Recommendation Report for Planning Permission for Works or Extension to a Dwelling

REF NO: BN/115/19/HH

LOCATION: Croft Cottage
Park Road
Barnham
PO22 0AQ

PROPOSAL: Single storey side and rear extension and porch to front

PROPOSED GROUND FLOOR PLAN
(scale 1:50)

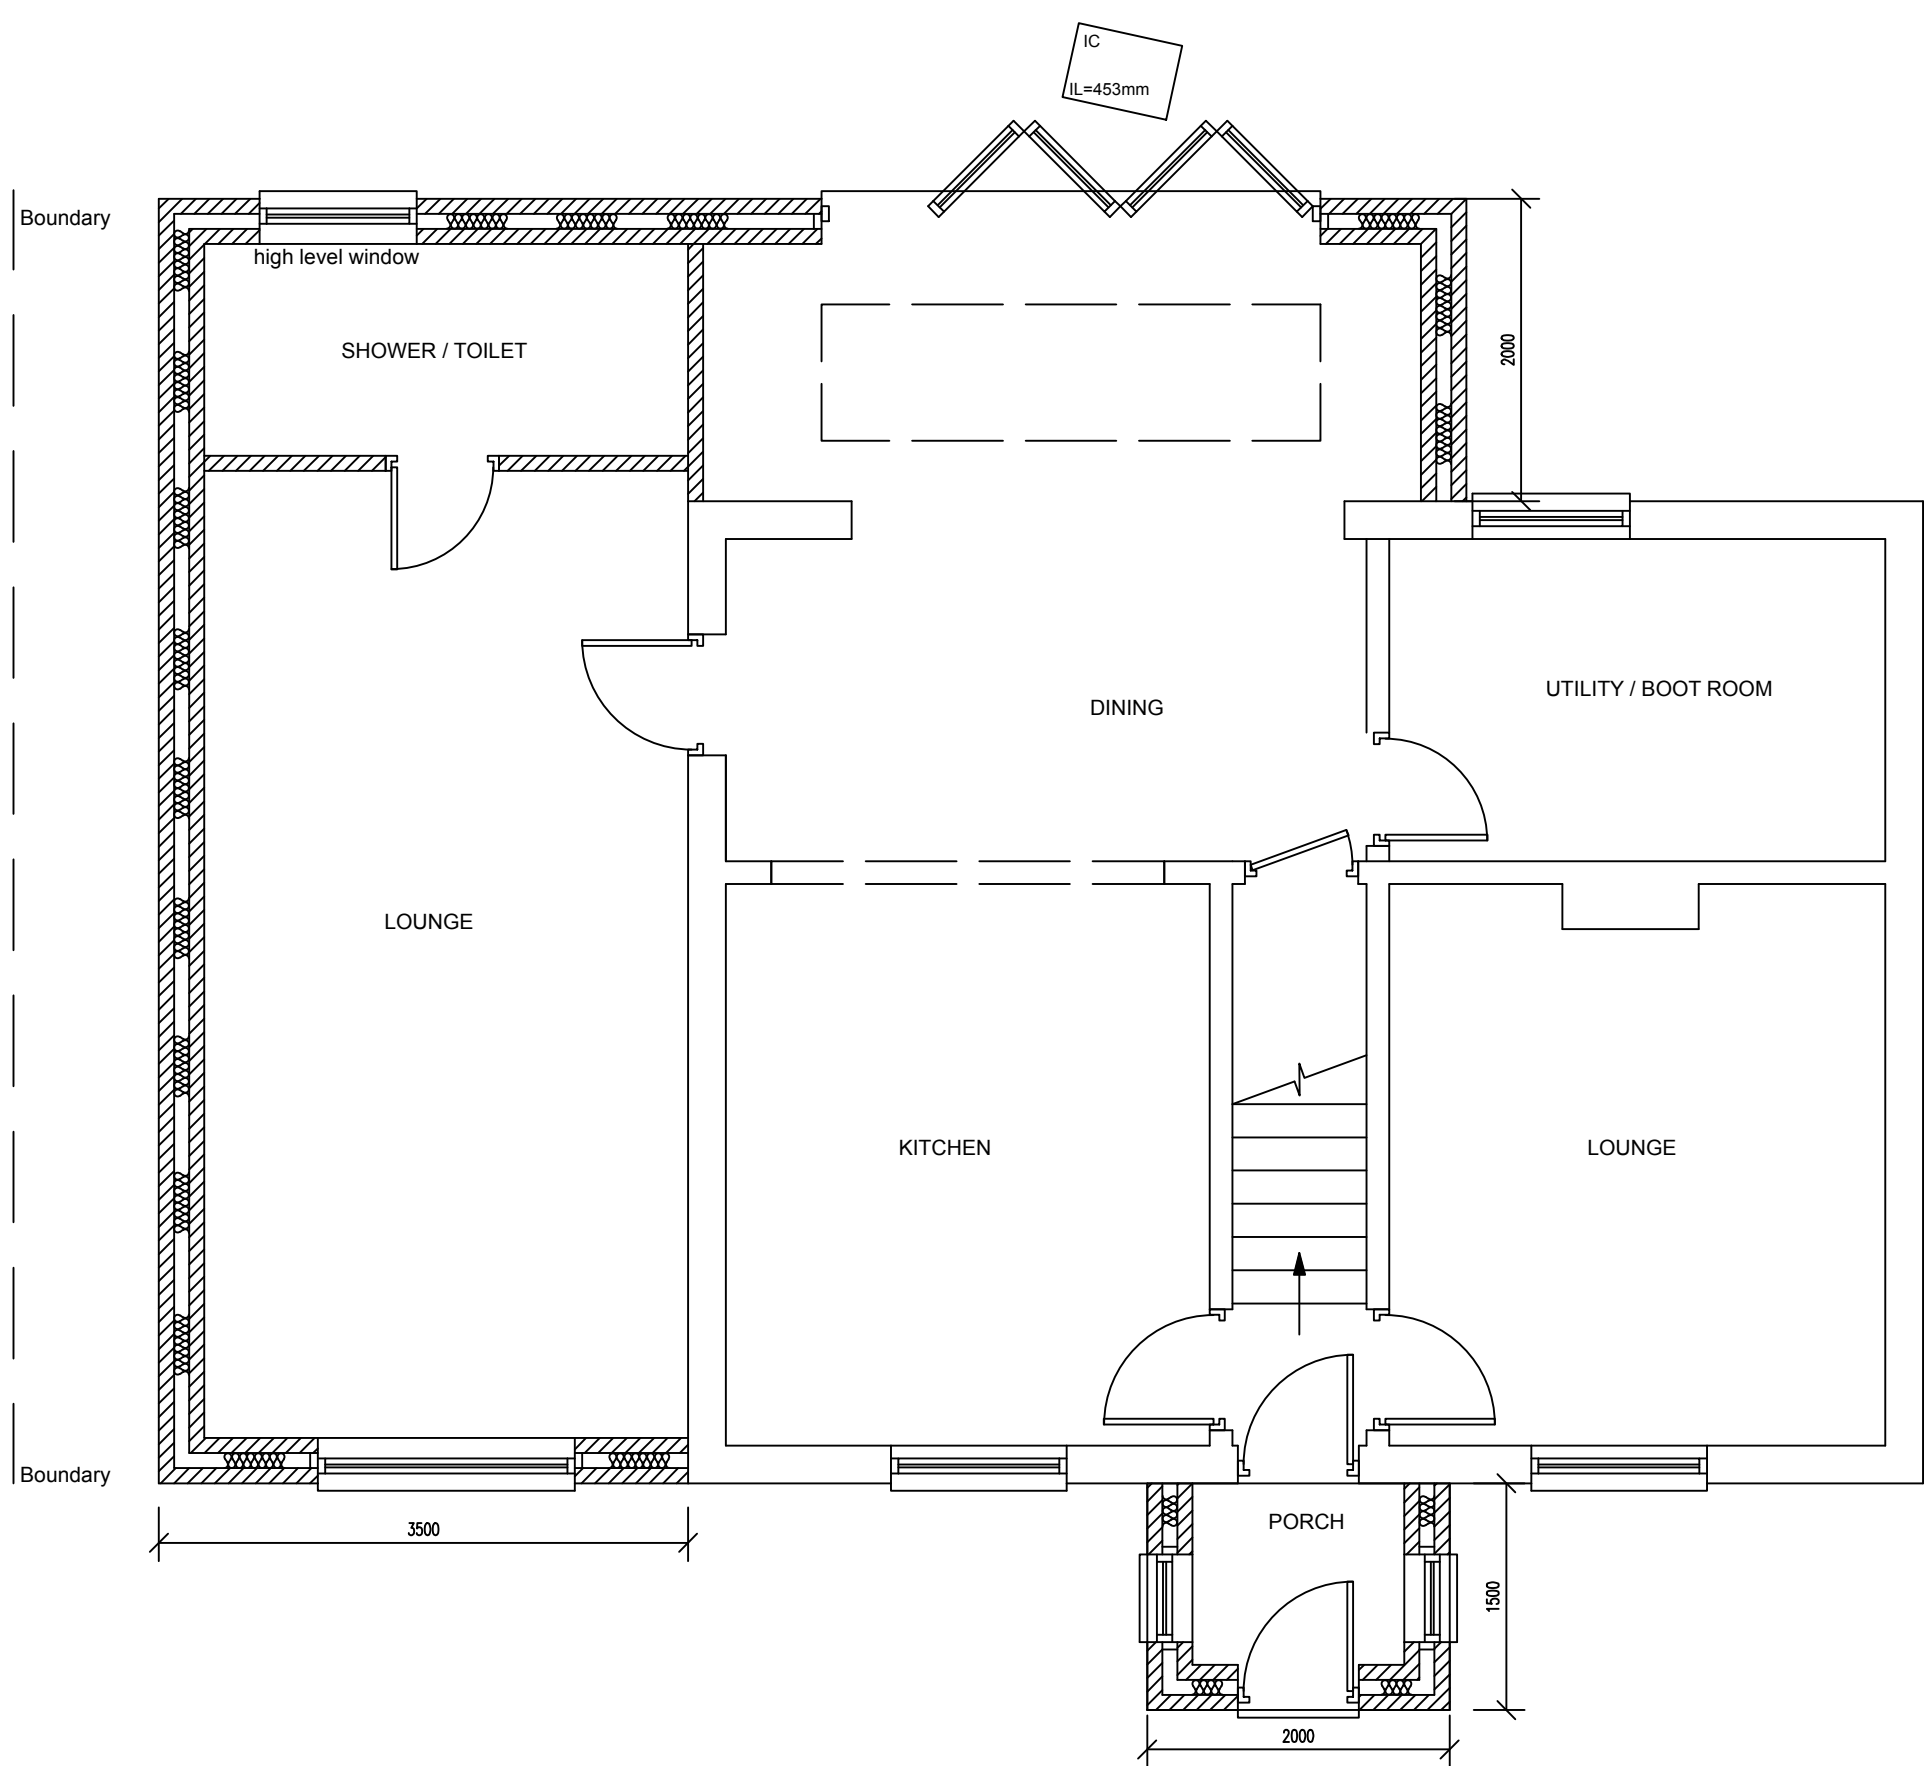
The extension has a width of 3.5m. This runs along the boundary at a depth of 8.45m. This angles away from the southern boundary retaining between 0.2-0.9m. The extension then extends 2m beyond the rear elevation and will replace an existing conservatory. Whilst the extension is situated relatively close to the boundary, the neighbouring property at 'Jevid' extends further west than the host dwelling and with the development at single storey, it is not considered to result in an overbearing impact.

There are windows to the side elevation of the property to the south, however with the extension at single storey and with no side windows proposed, the development is not considered to result in significant impacts.

There will be doors to the rear extension however these are not considered to give rise to impacts additional to that are already achievable from the existing conservatory. 4m is retained to the northern boundary and as such, is not considered to give rise to adverse impacts upon this elevation

PROPOSED ROOF PLAN
(scale 1:100)

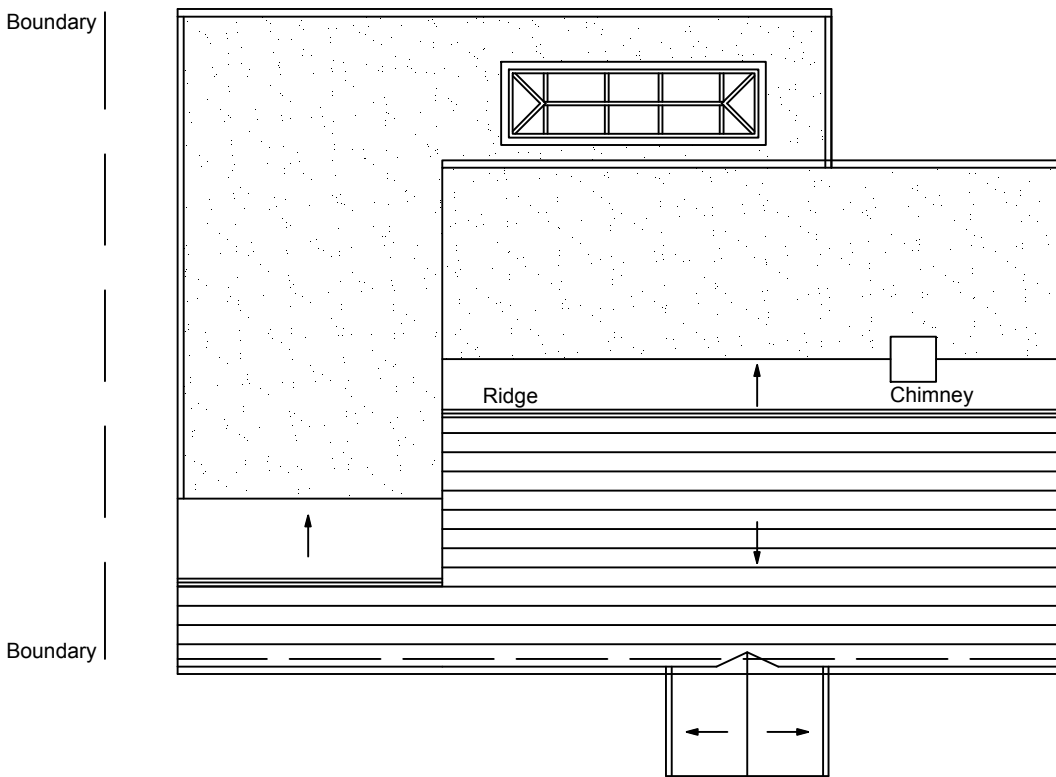
The extension will have a pitched roof to match the front elevation with a maximum height of 3.75m. It will then alter to a flat roof as it extends along the side and rear with a height of 2.8m.

PROPOSED SITE PLAN
scale 1:200

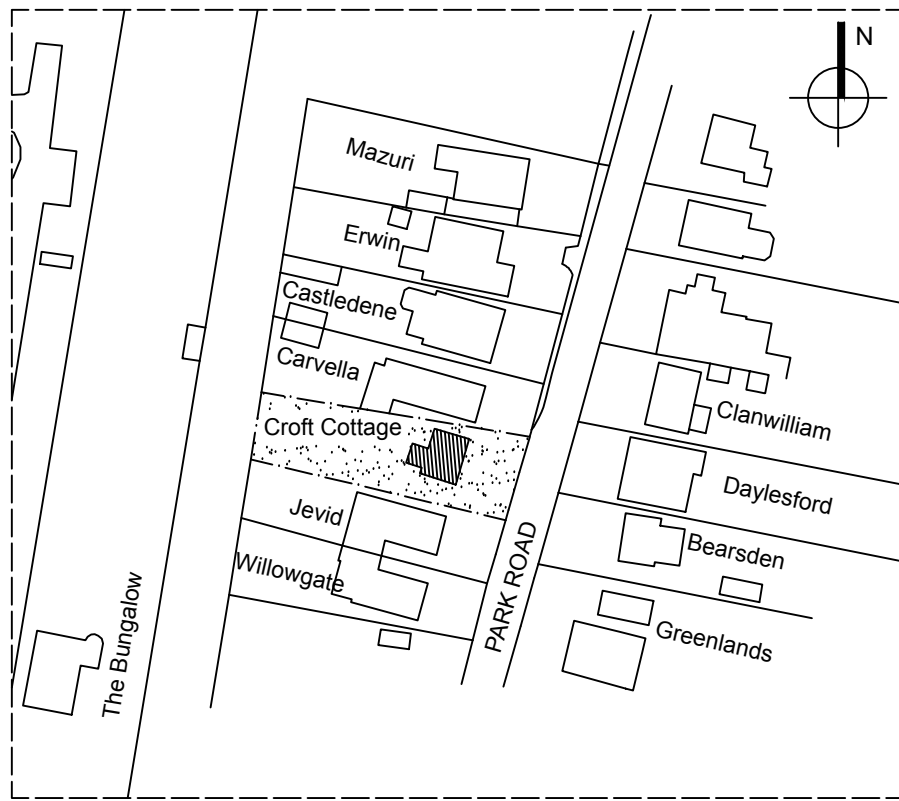
There is an existing covered porch area and a new one is proposed however the depth is increased from 0.5m to 1.5m. Due to its depth it does extend marginally beyond that of the established development line. However with 8m retained to the front boundary, it is not considered to result in an unduly dominant appearance in which a refusal is justified.

PROPOSED FRONT ELEVATION
(scale 1:50)

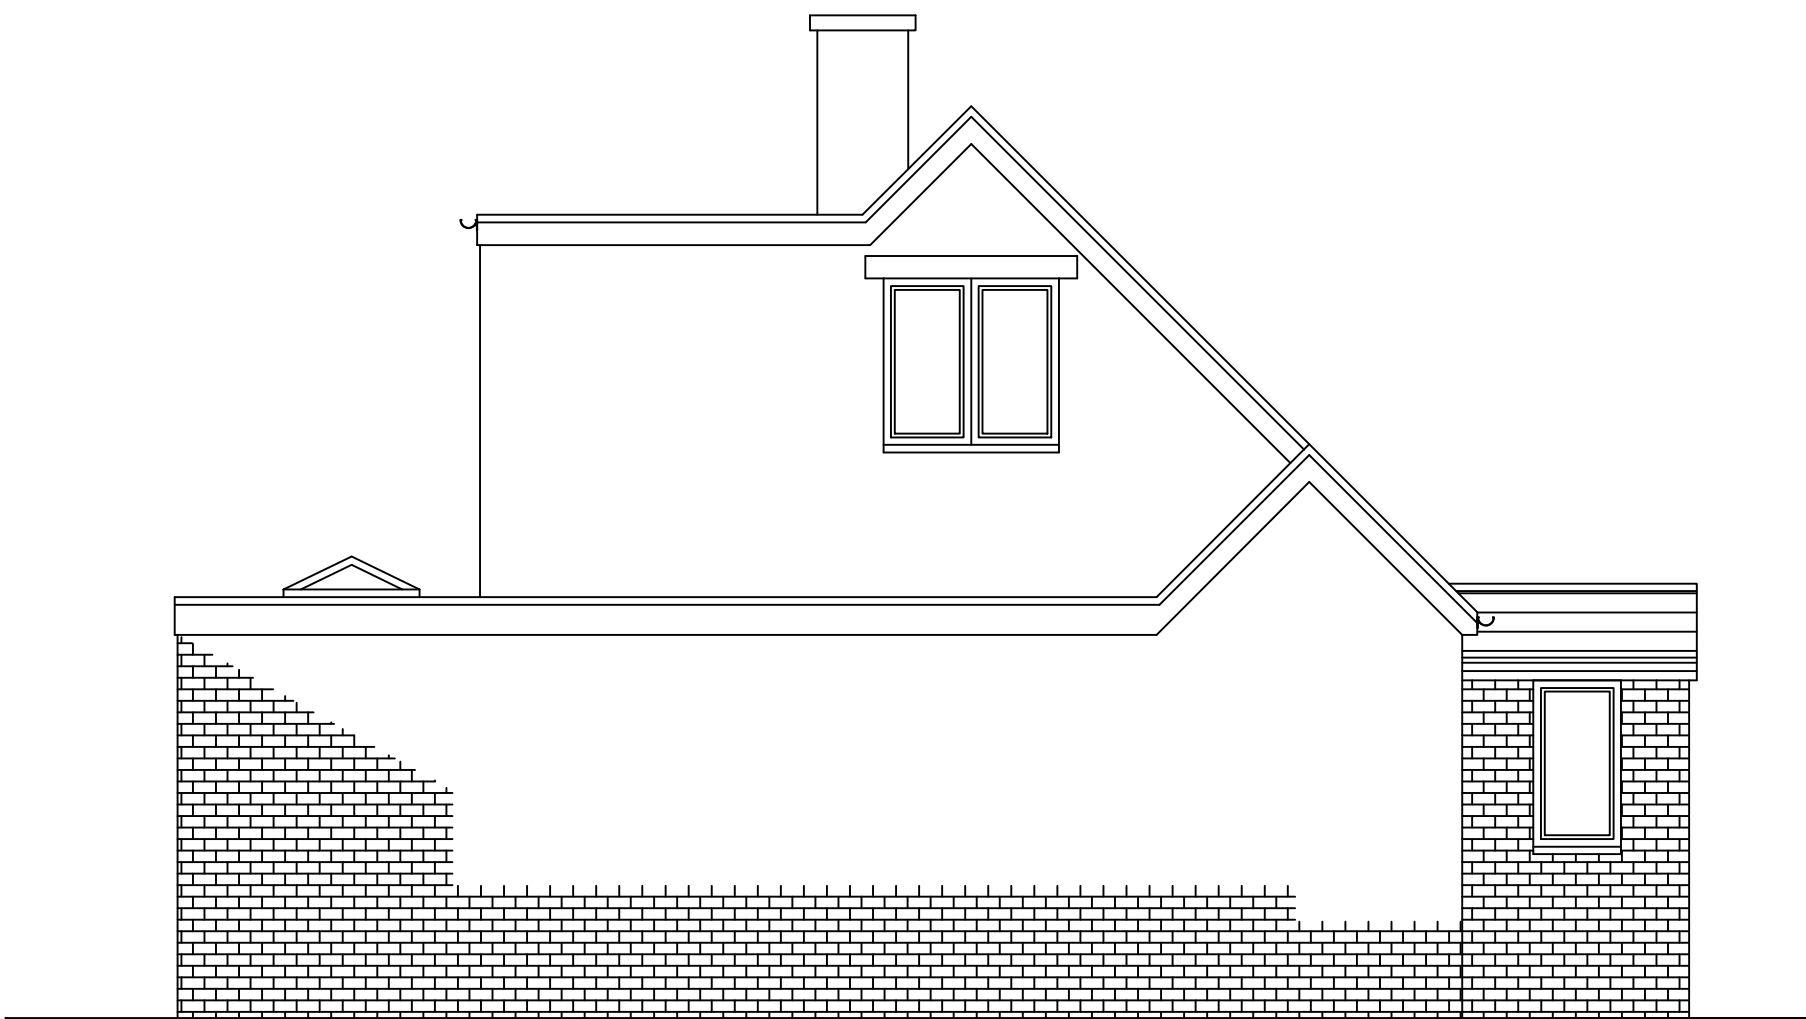
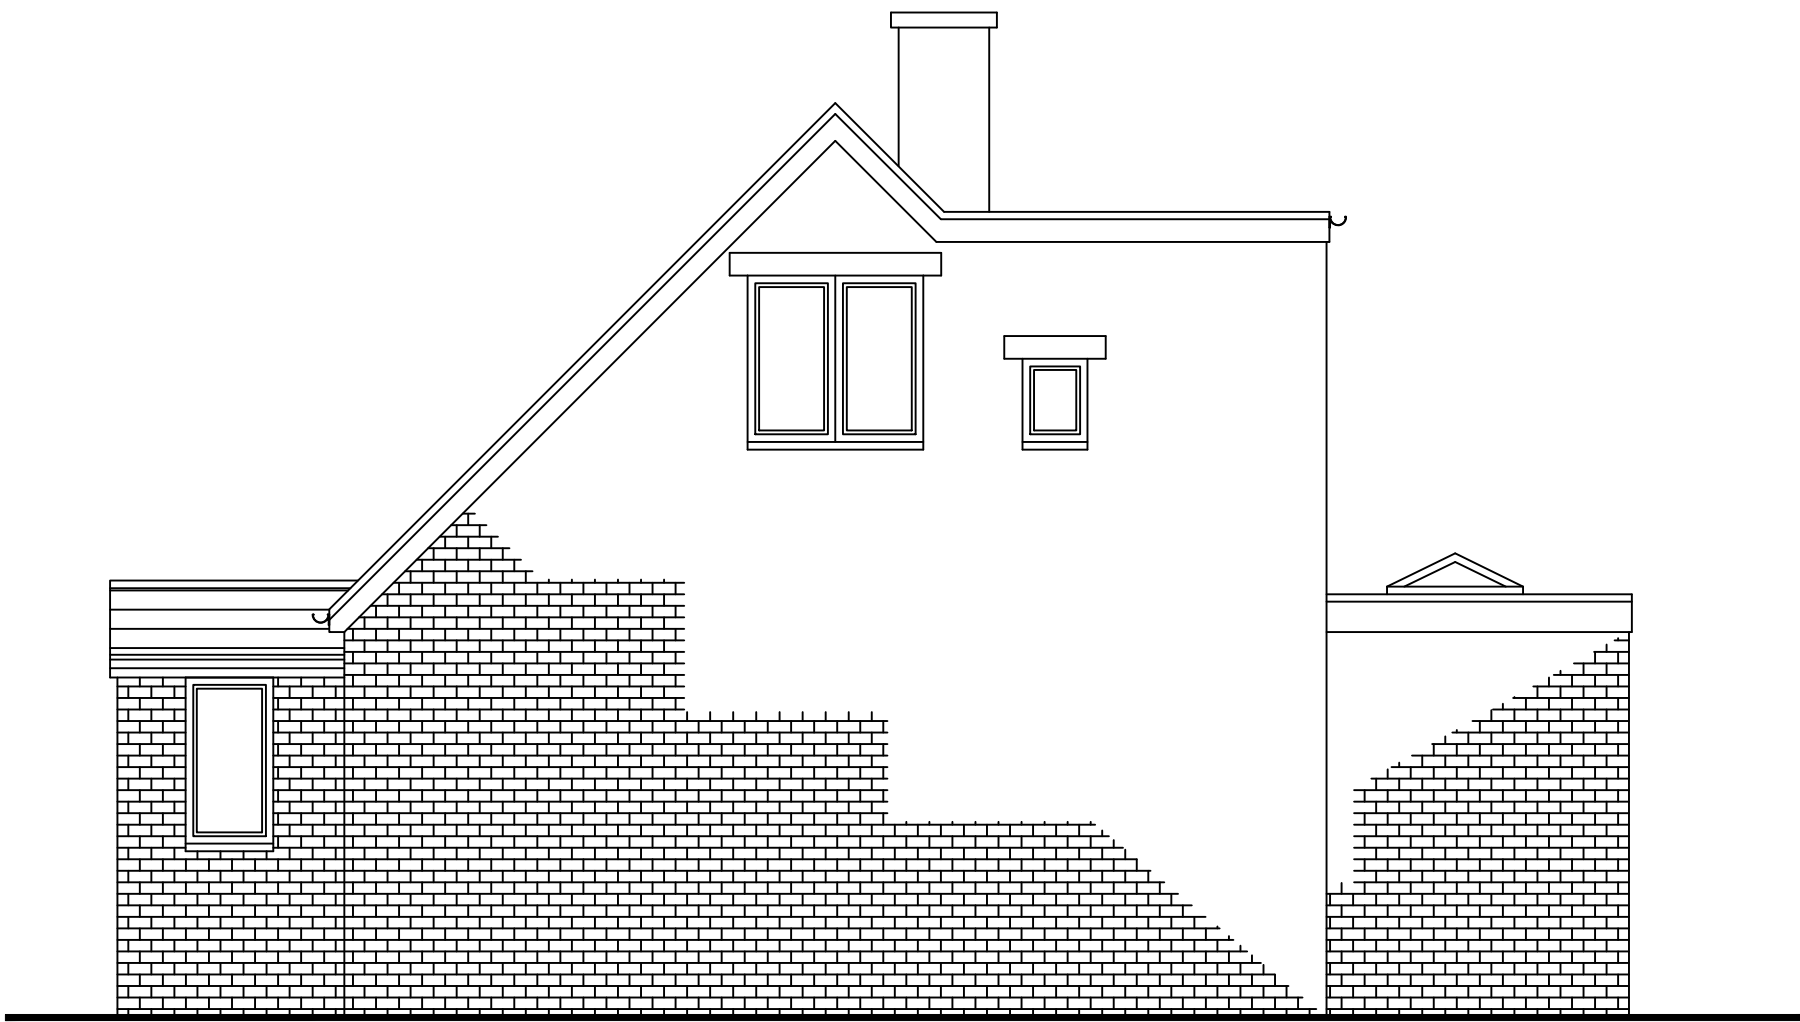
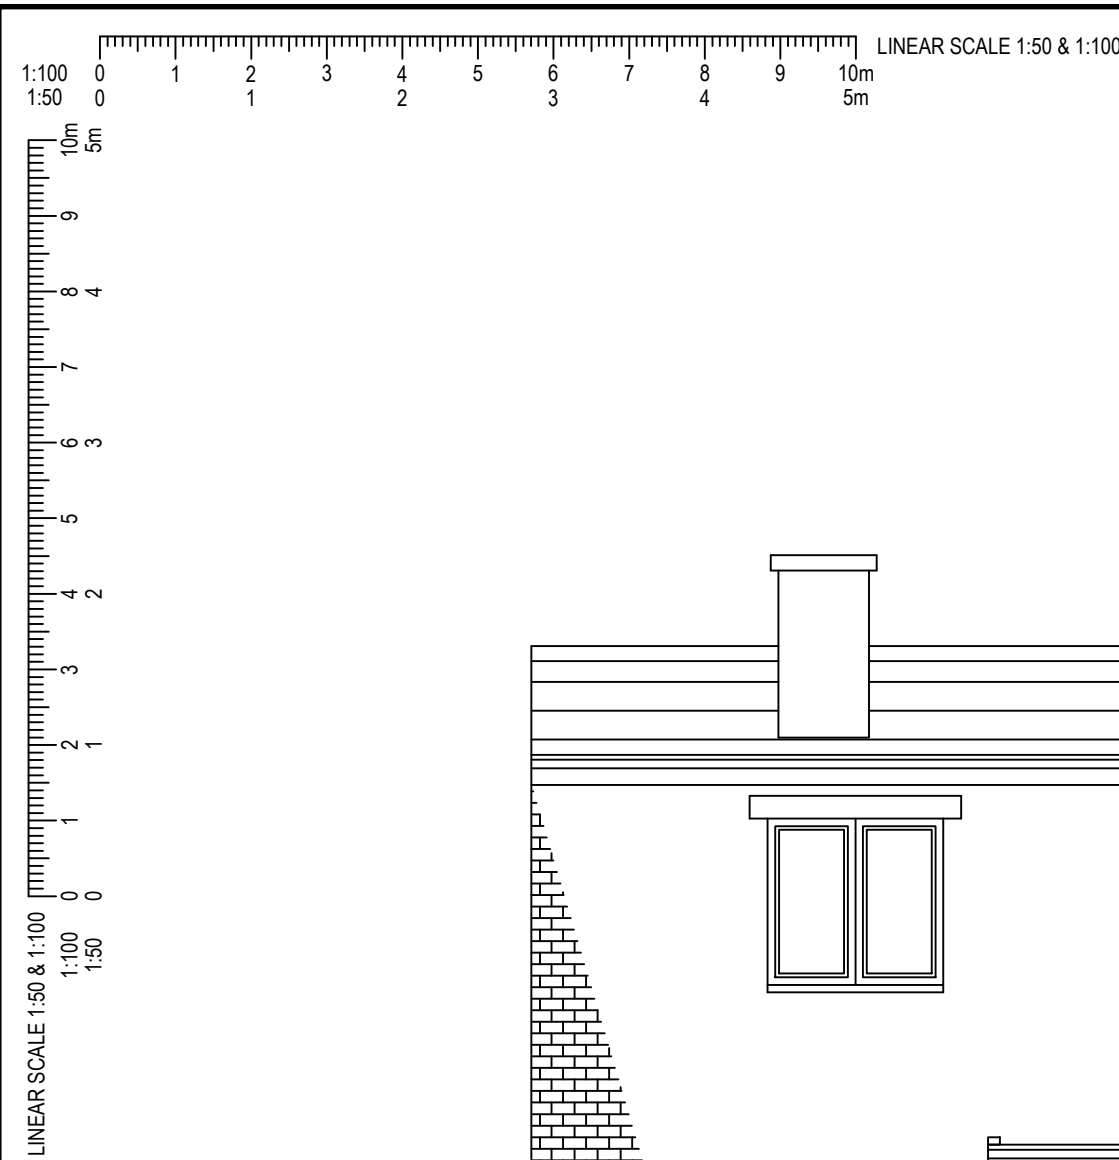
The extension will be situated to the southern elevation and wrap around the rear of the property to form a L shape. The extension will be single storey and appears subservient to the host dwelling. The design of the side extension is sympathetic in appearance to the host dwelling with eaves matching existing. Materials proposed will also match existing which helps to ensure the development appears well integrated.
